**Consultation Response from: KC Environmental Health (Pollution & Noise Control)**

**2026/91233 - 50, Orchard Street, Savile Town, Dewsbury, WF12 9LH**

**Erection of detached dwelling**

**Responding Date:**  
**Monday, 08 June 2026**

25-047-05

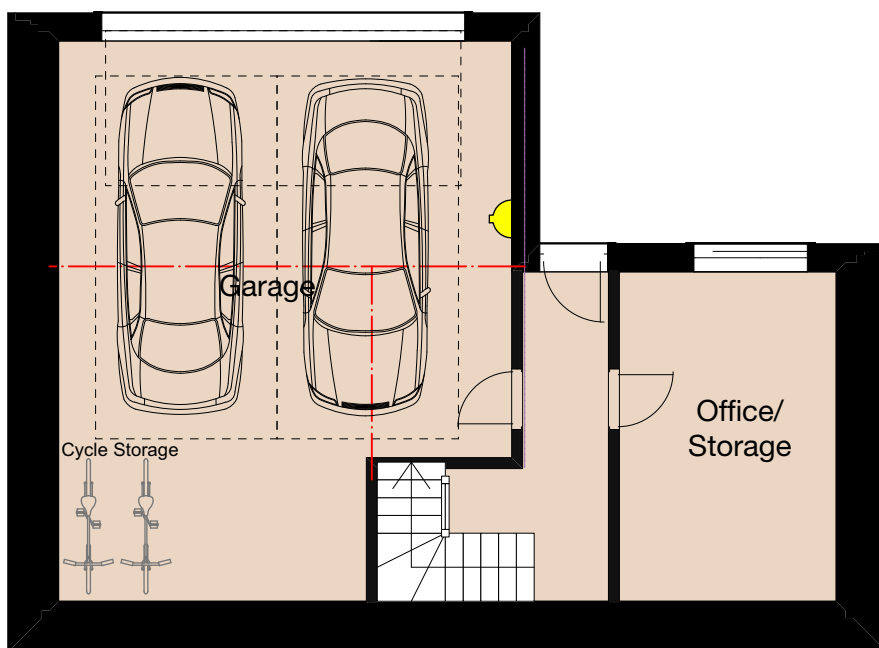
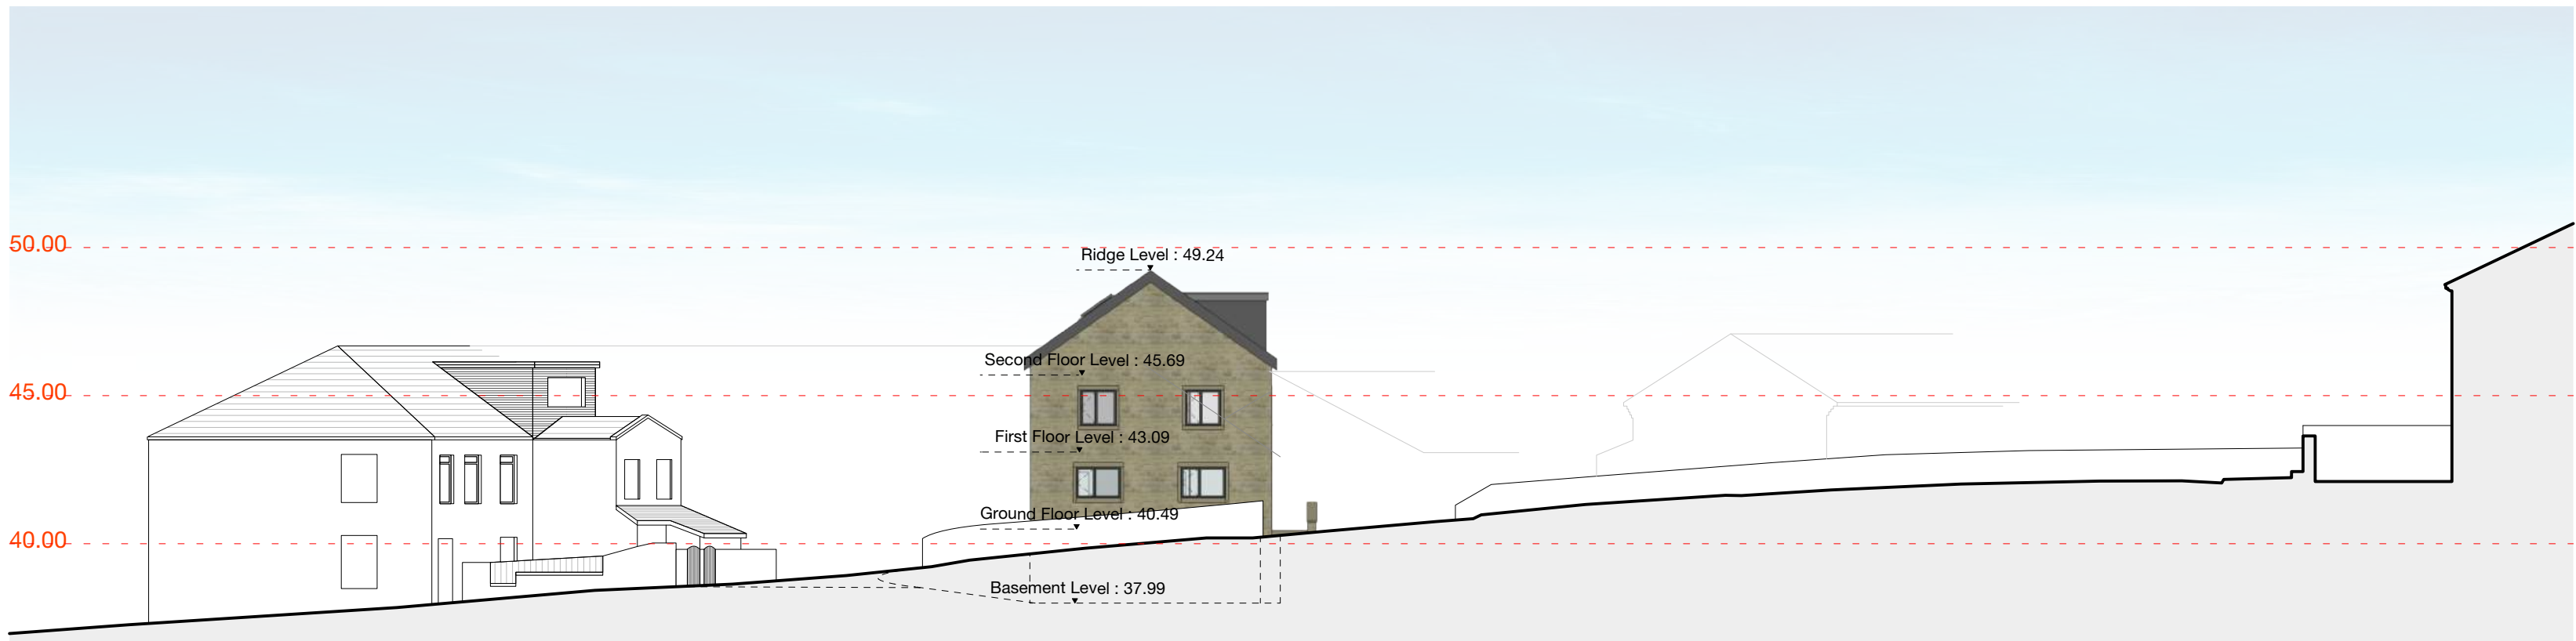
In an application of this nature, it is expected that the application is accompanied with a provision for charging electric vehicles. The applicant has identified within drawing no. 25-047-05, dated 18<sup>th</sup> November 2025, prepared by Code L6 Architects Ltd that “OLEC EV/OLEV Home Car charge Point: The cable and circuitry ratings for the charging points shall be of adequate size to ensure a minimum continuous current demand of 16 Amps and a maximum demand of 32Amps. Located in garage” is to be provided. This should be ensured by way of condition, or a suitable alternative means to ensure the development includes the provision for charging electric vehicles.

Before first occupation, a scheme outlining the specific facilities for charging electric vehicles and other ultra-low emission vehicles for each parking space at the premises must be submitted to and approved in writing by the Local Planning Authority. This scheme must meet the minimum requirements in the current West Yorkshire Low Emission Strategy (WYLES) document. The approved facilities for charging electric vehicles must be installed before occupation and retained for use thereafter.
